# CITY OF ALBUQUERQUE

**RE: 1739 Soplo Rd SE  
Grading & Drainage Plan  
Engineer's Stamp Date: 1/19/26  
Hydrology File: N23D002  
Case # HYDR-2026-00016**

Based upon the information provided in your submittal received 1/19/2026, the Grading & Drainage Plan **is not approved** for Grading Permit or Building Permit. The following comments need to be addressed for approval of the above referenced project.

ENGINEER'S SEAL	LOT 22 BLK 49A FOUR HILLS VILLAGE 1739 SOPLO ROAD SE GRADING AND DRAINAGE PLAN	DRAWN BY DEM
		DATE 1-17-26
DAVID SOULE P.E. #14522		1738 Soplo Road SE, Albuquerque, NM 87109 (505) 321-8099
1/24/26	SHEET # C1	JOB #

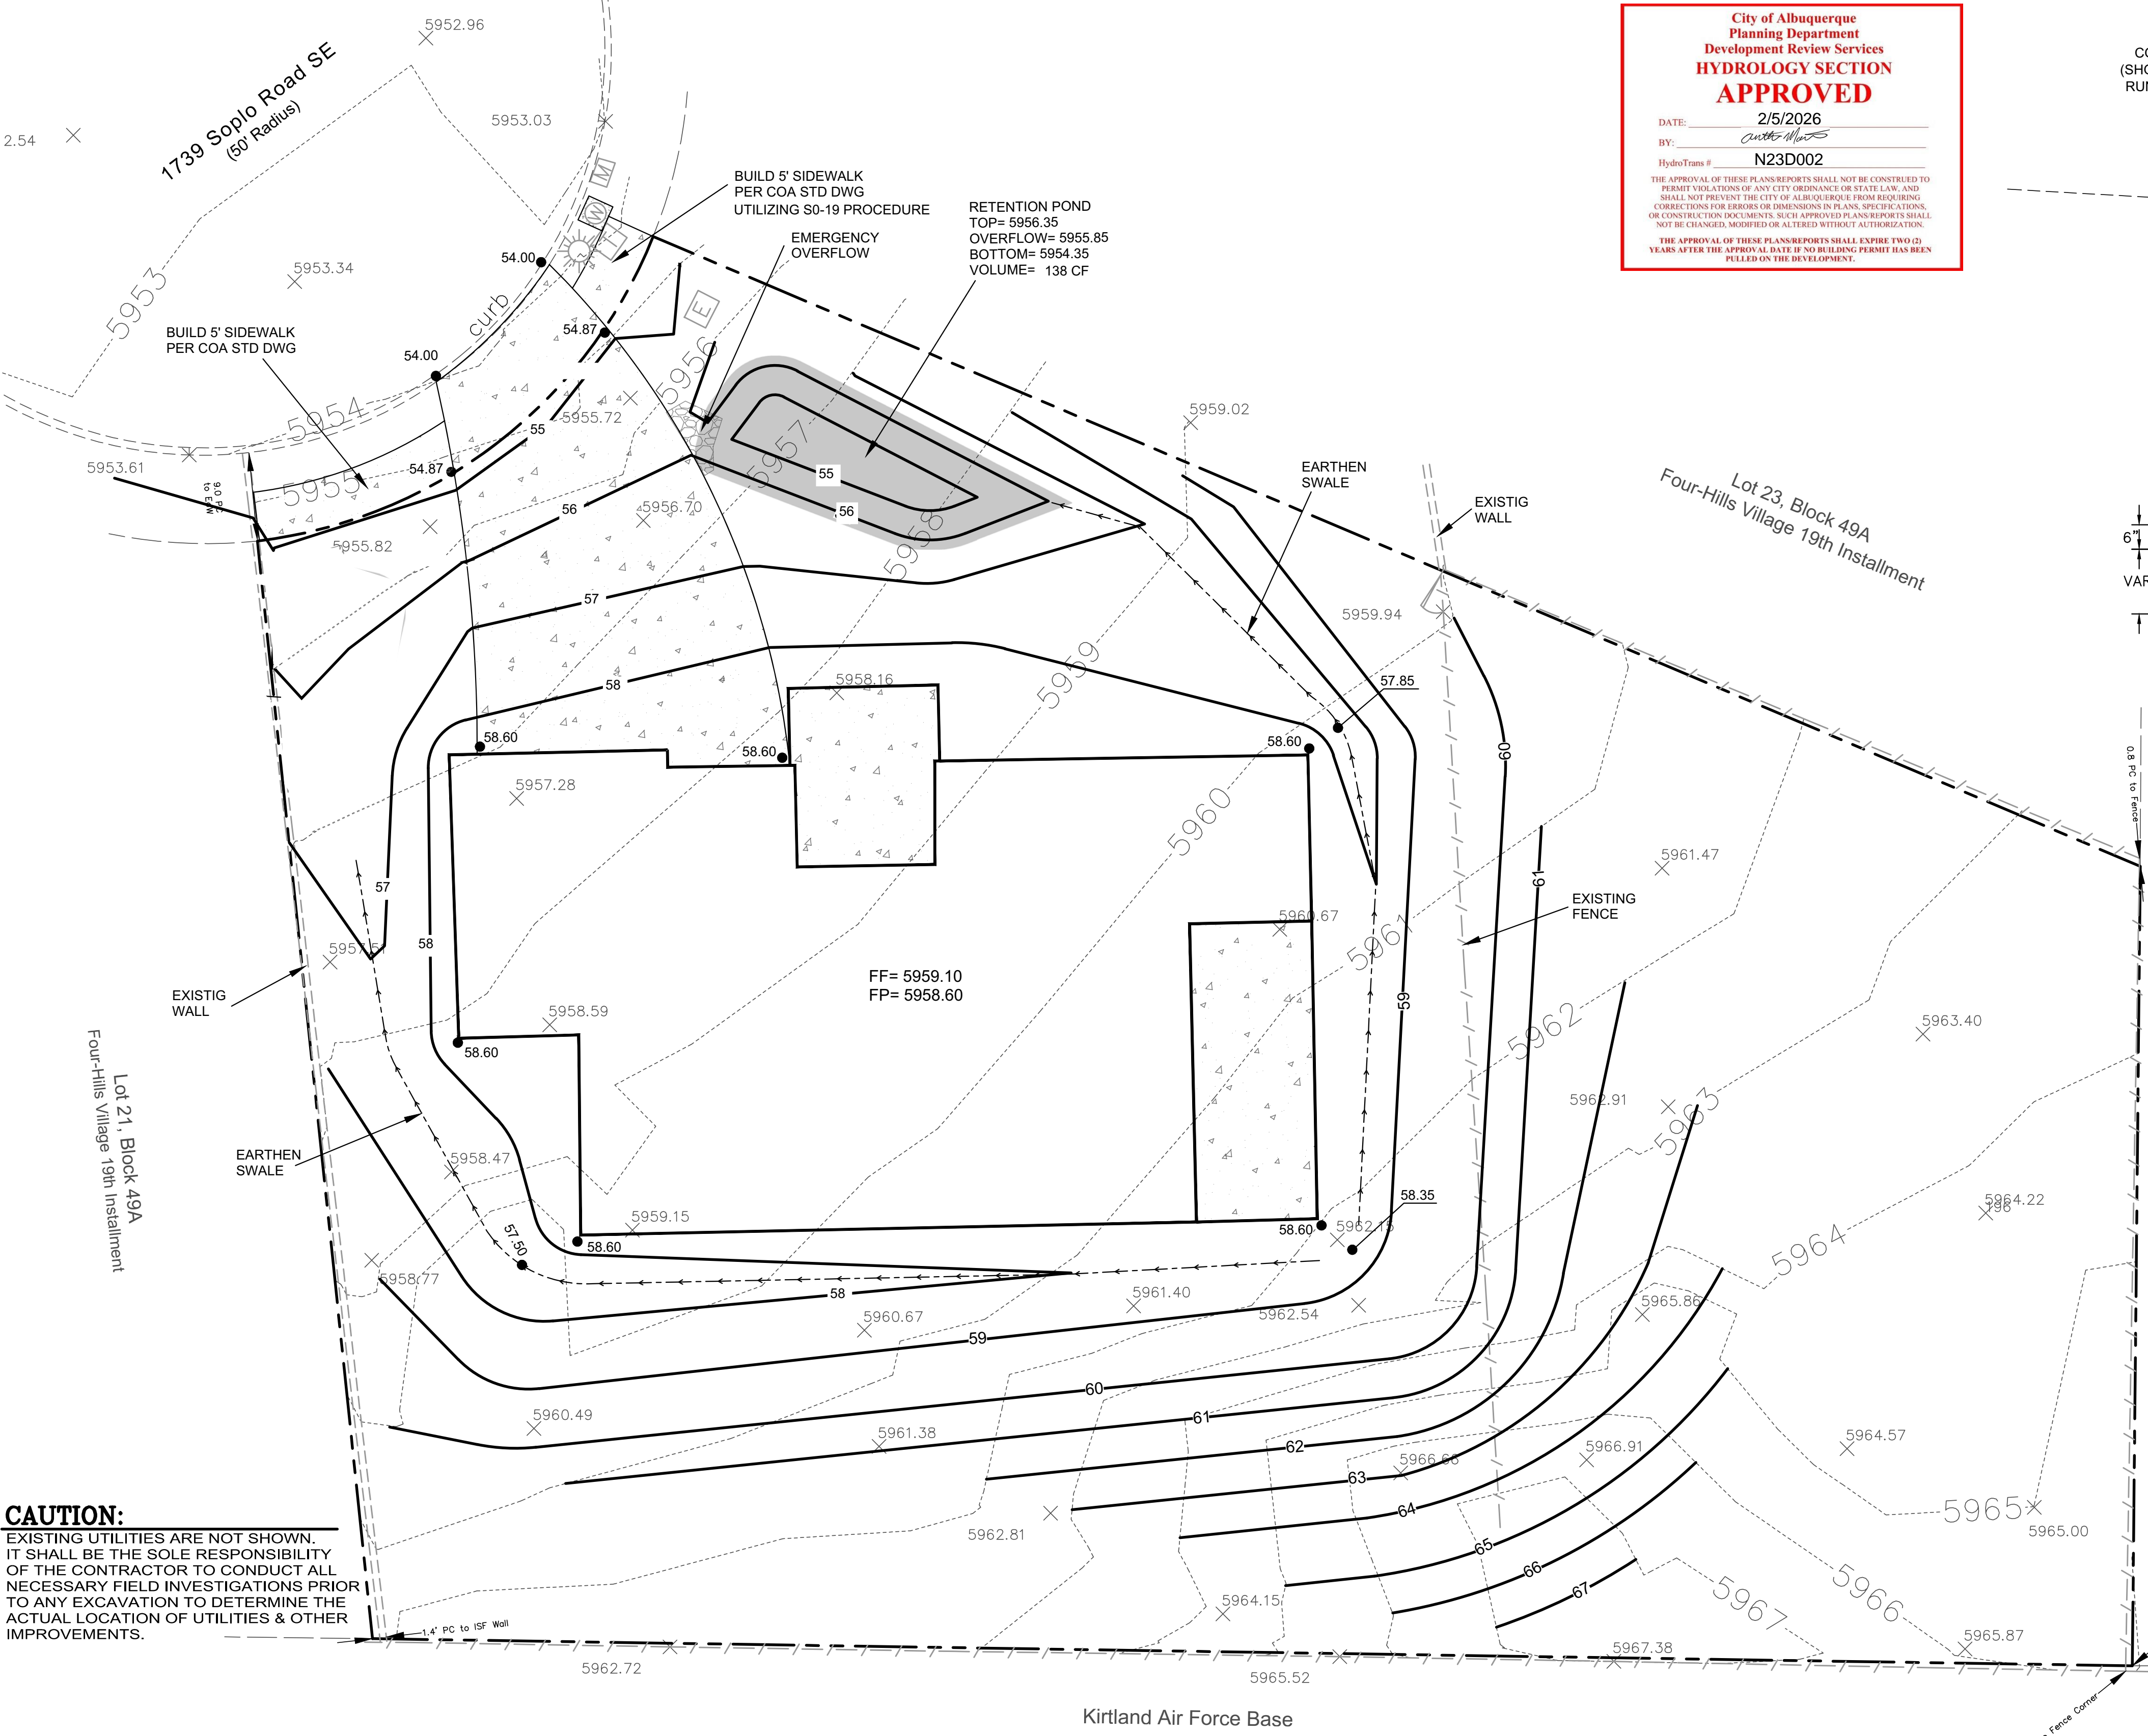
1. An SO-19 Permit will be required and should be included on the request. Please include the [standard SO-19](#) notes on the grading plan.
2. Please follow the DPM Article 6-12 Stormwater Quality and Low-Impact Development for the sizing calculations. To calculate the required SWQV, multiply the impervious area draining to the BMP by 0.42 inches for new development sites and 0.26 inches for redevelopment sites. Since this project is a new development, please use 0.42 inches for the calculation.
